Development Facilitation Team (DFT) – Review Comments

Project No: PR-2023-008999

Application For: SD-2024-00013-BULK LAND PLAT

REQUEST: BULK LAND PLAT INNOVATION PARK III TRACTS A-N

BULK LAND PLAT
INNOVATION PARK III
TRACTS A-N
 (BEING A REPLAT OF TRACT 18 ARTISTE)
 CITY OF ALBUQUERQUE
 BERNALILLO COUNTY, NEW MEXICO
 JANUARY, 2024

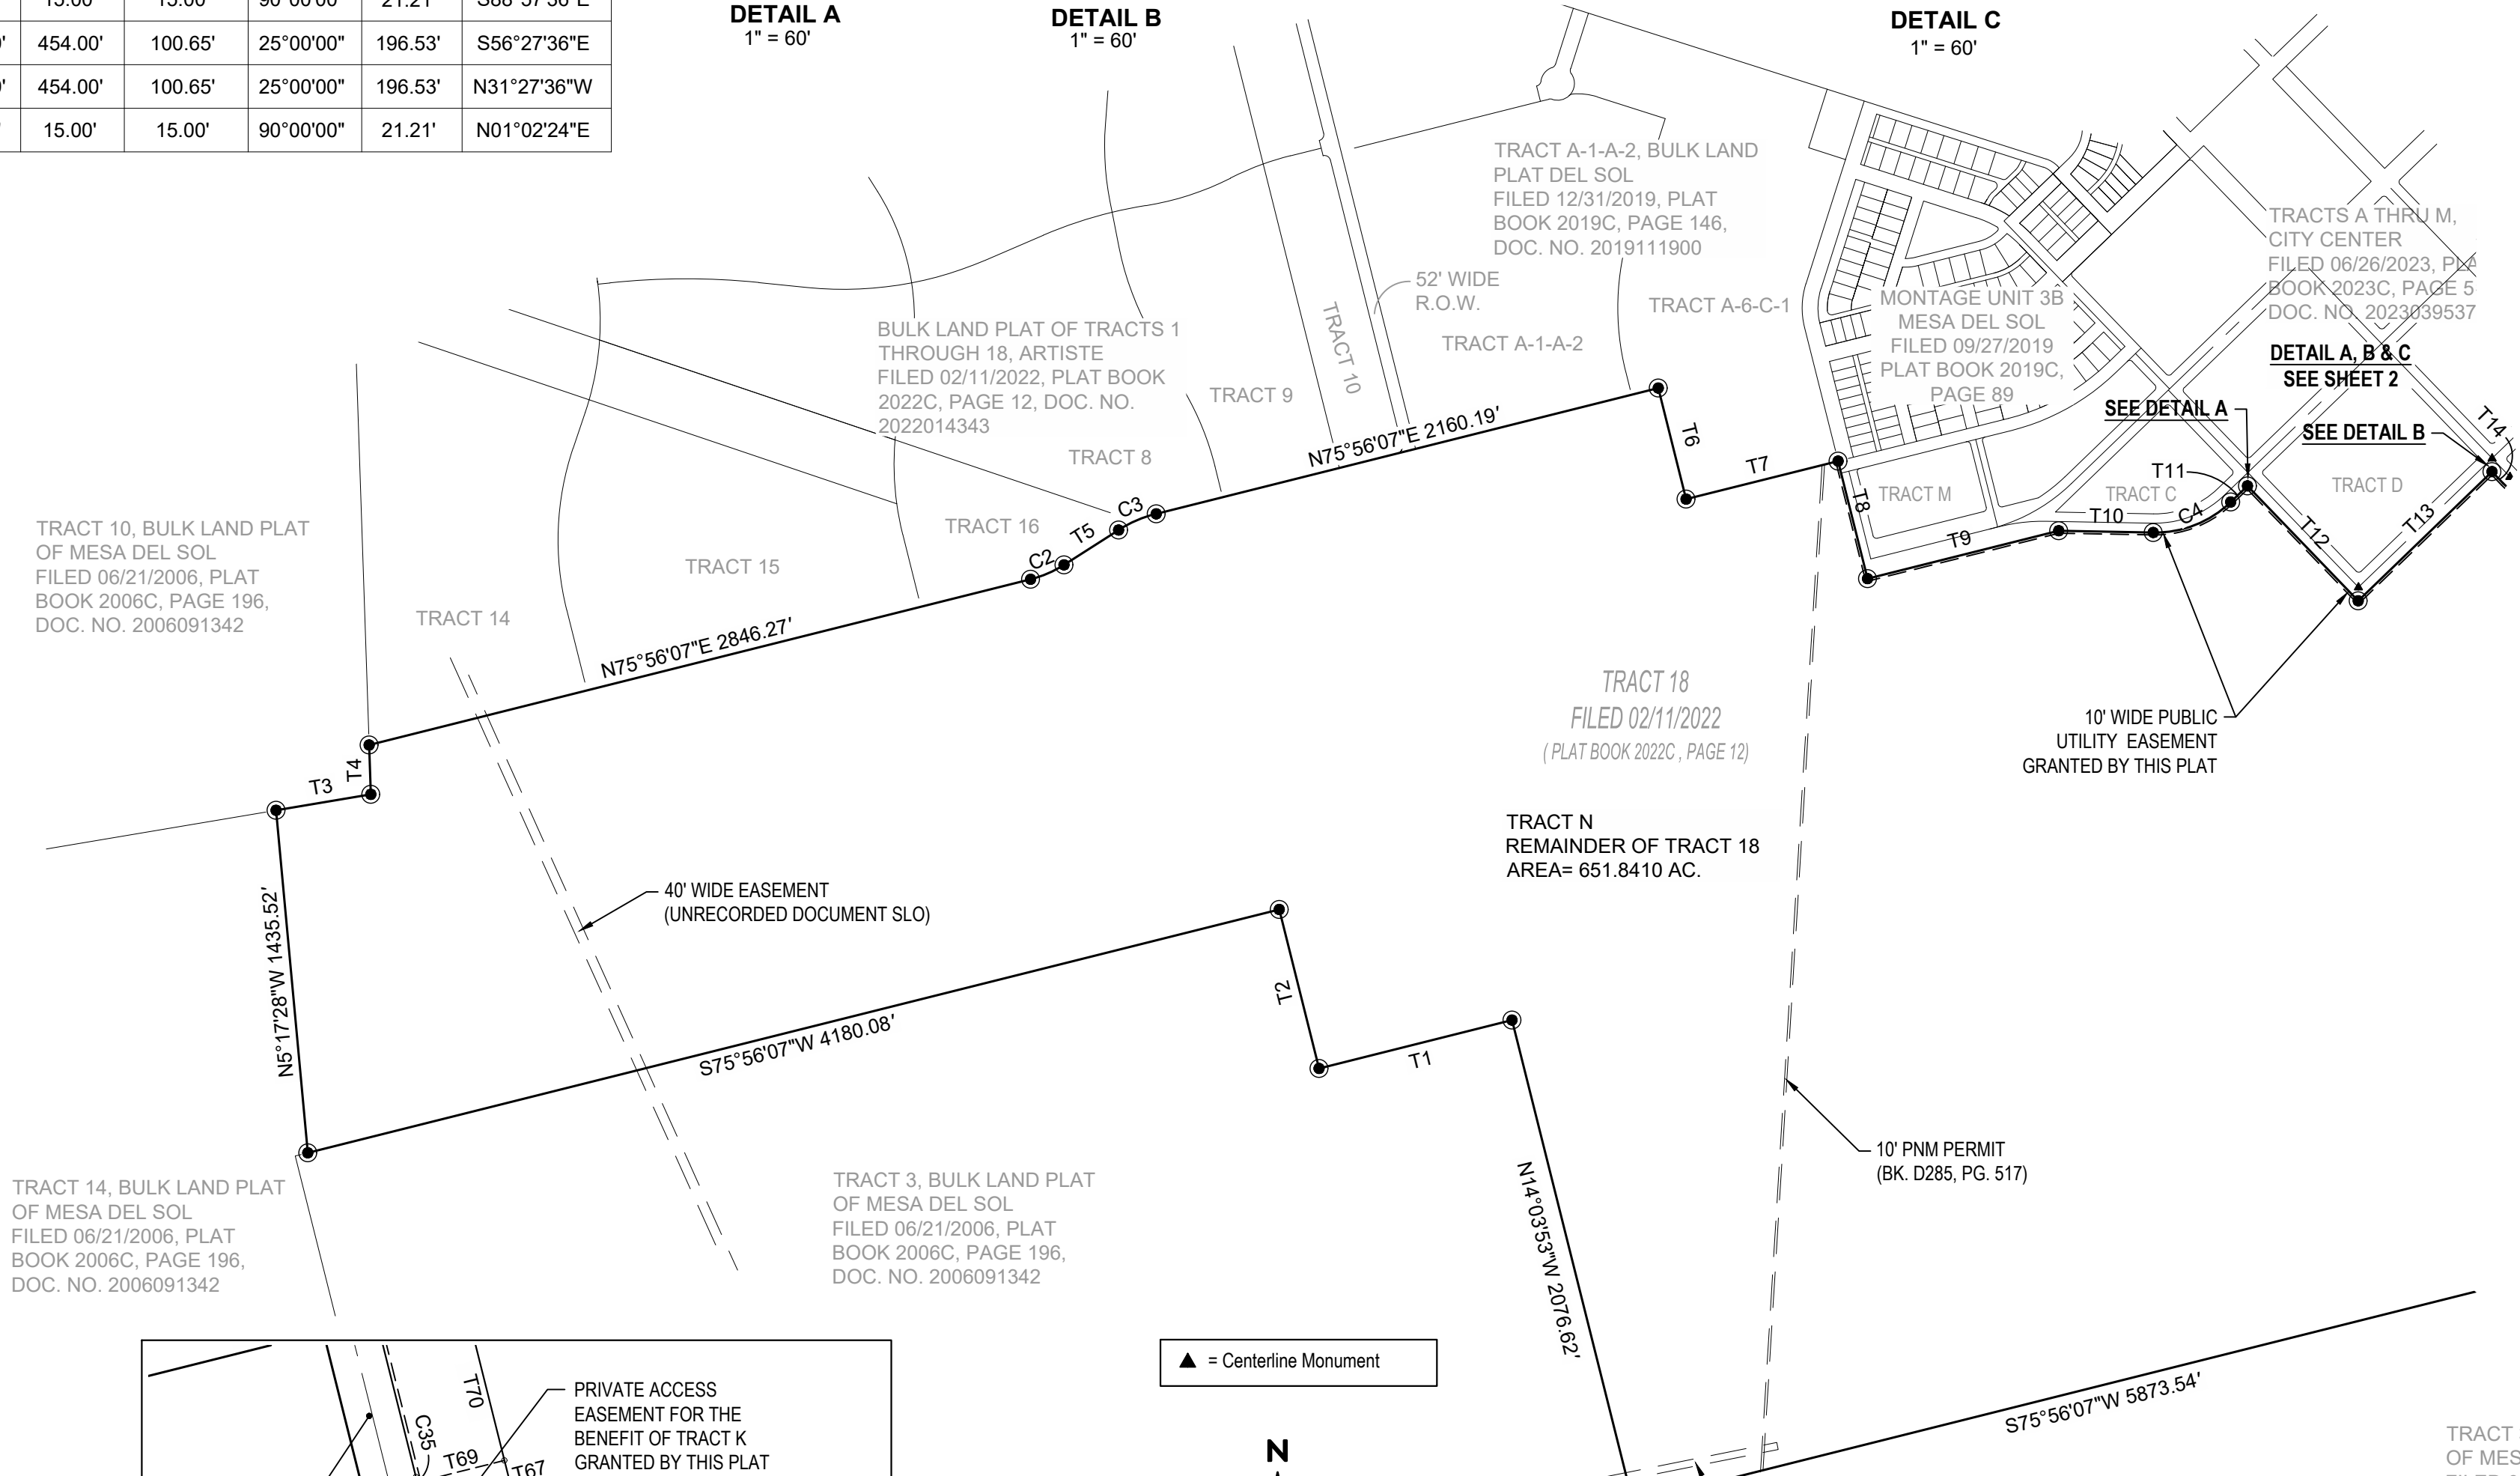
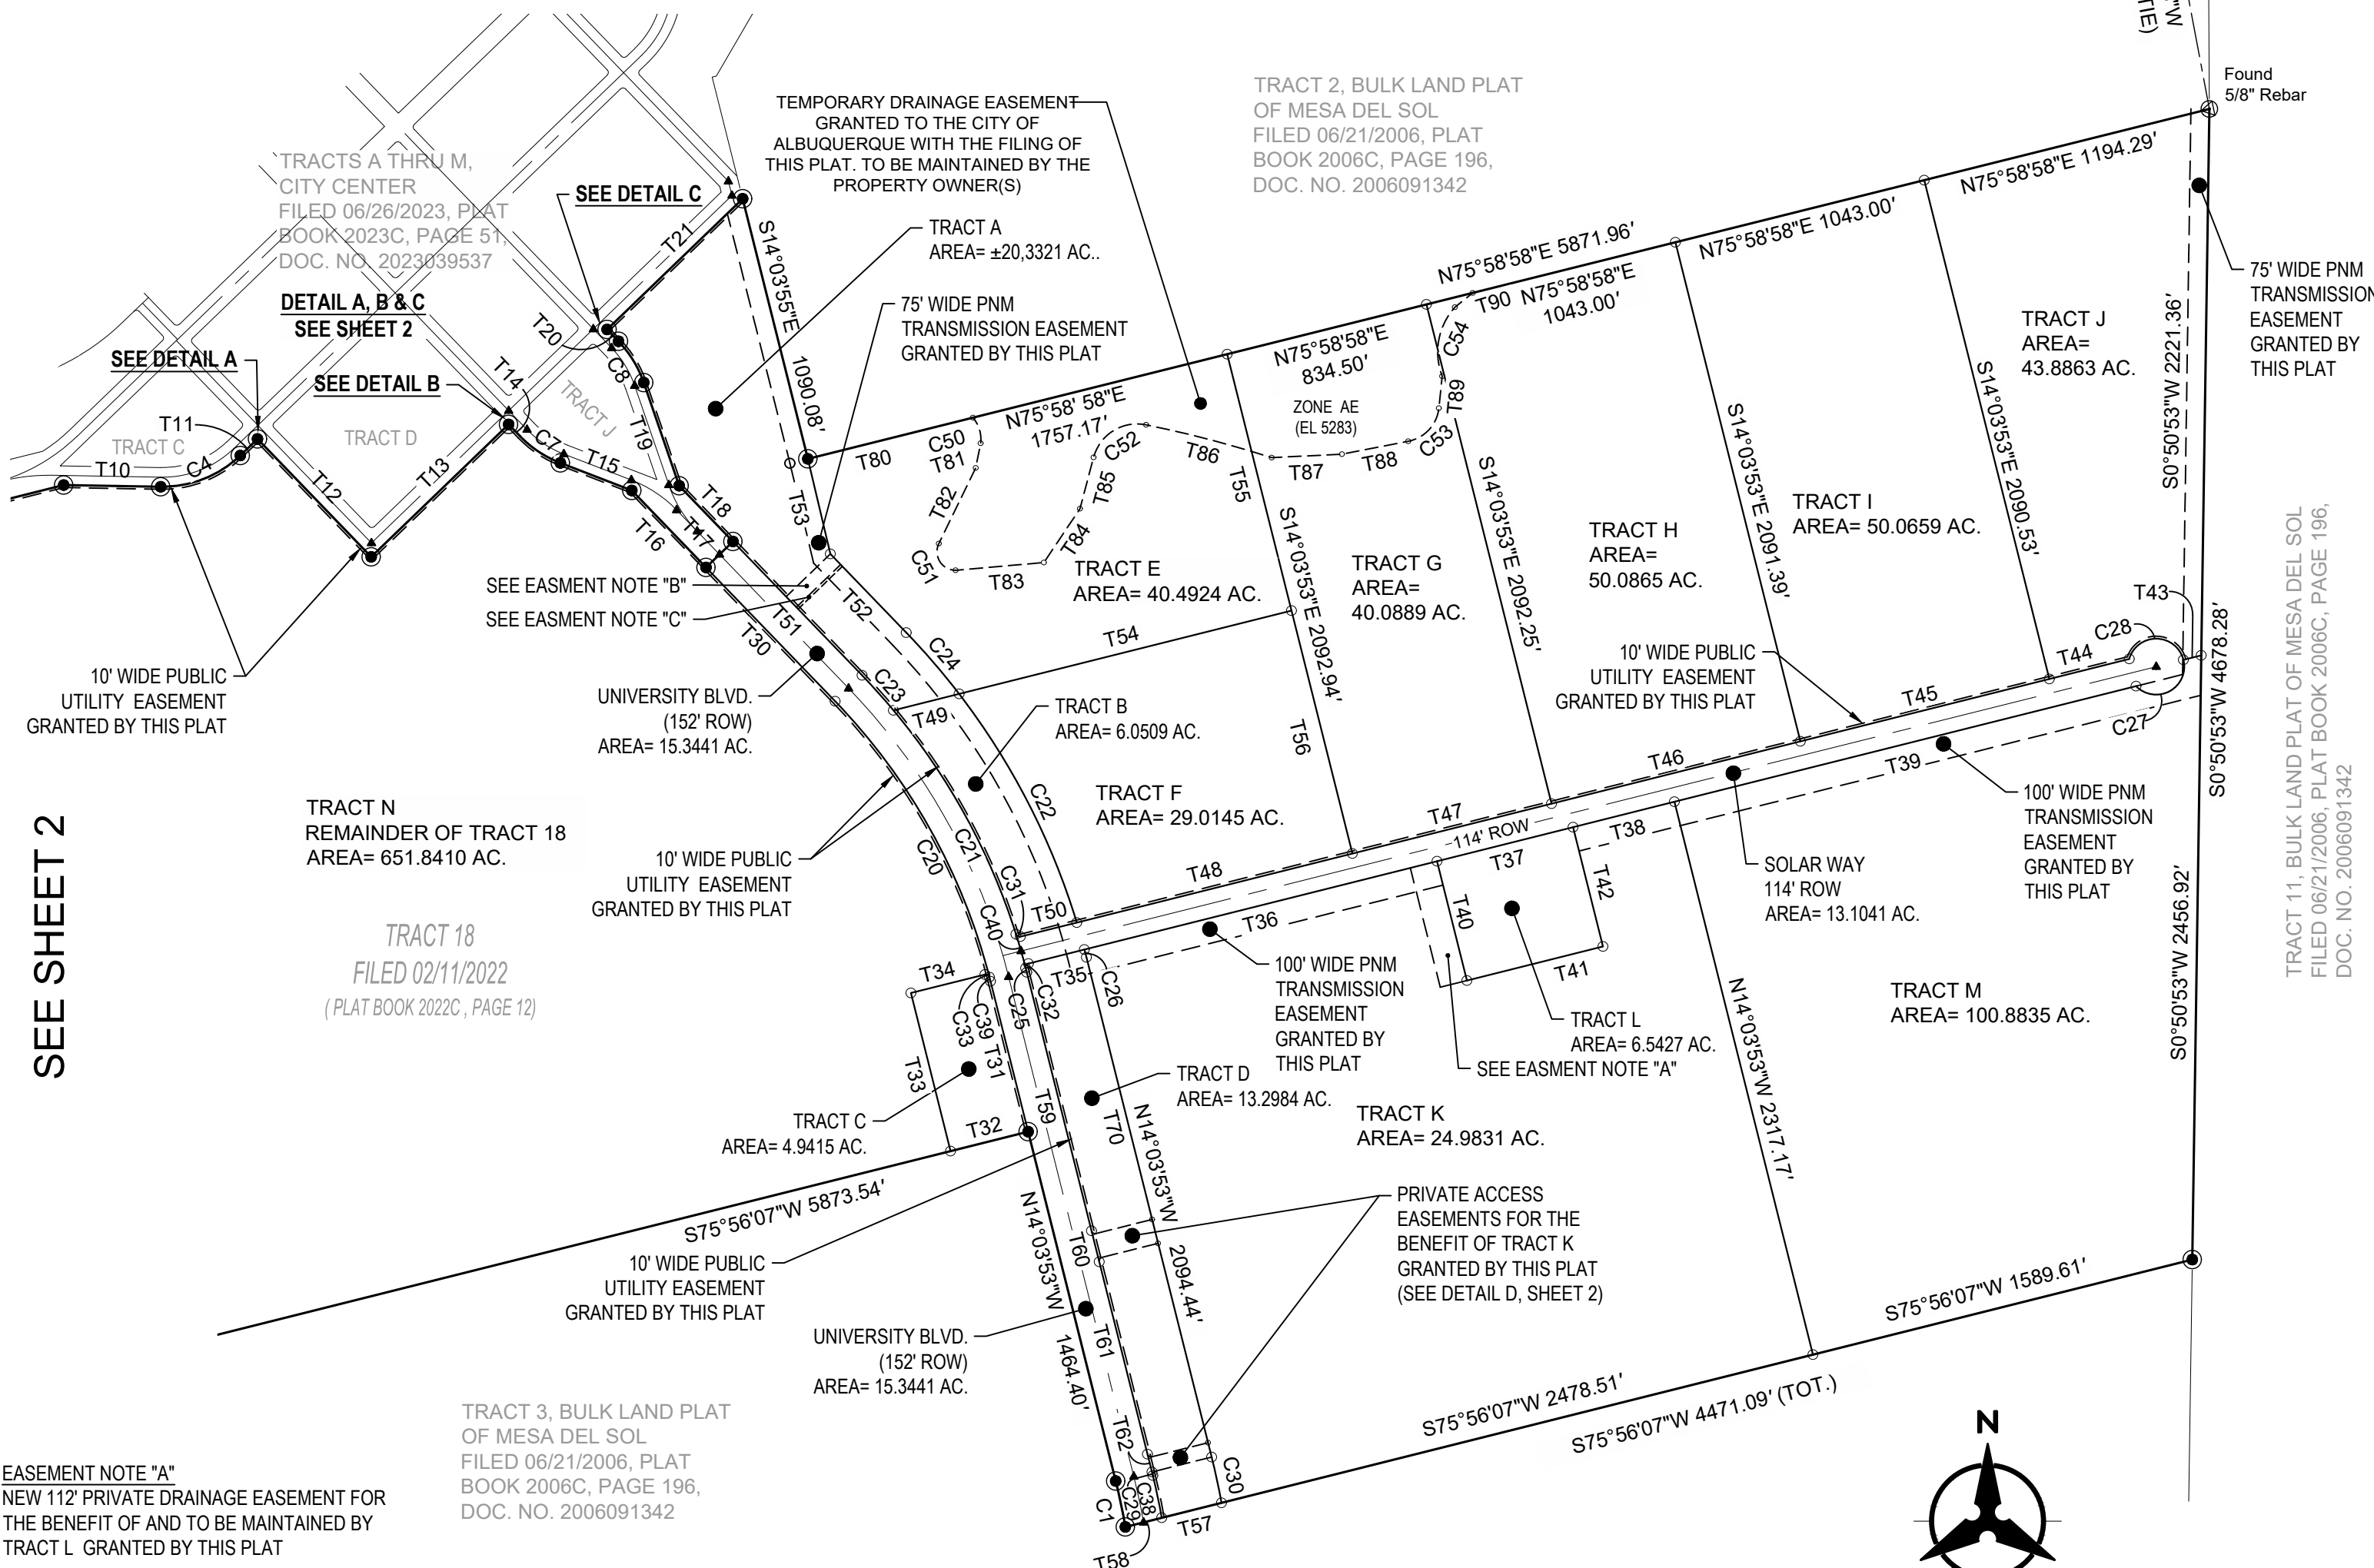
1. How will Tract 11, get service?
 - a. Please provide a public water and public sanitary sewer easement across Tract M or J to make the connection.

- The acreage for Tract K appears to be incorrect; Tract K is depicted as being 24.9831-acres in size on the Plat, while the site area of the Site Plan Administrative DFT currently under review on the site is approximately 125-acres. Please confirm if the acreage for Tract K is incorrect, and correct the acreage for Tract K on the Plat if needed.

- In accordance with the AMAFCA's Drainage Policy, a public drainage easement needs to be granted for the Zone AE floodplain to a public entity. The metes and bounds of the public drainage easement must be shown on the plat. For this plat, AMAFCA will defer its requirement for grant of easement to the City of Albuquerque as the Floodplain Administrator and NFIP community.
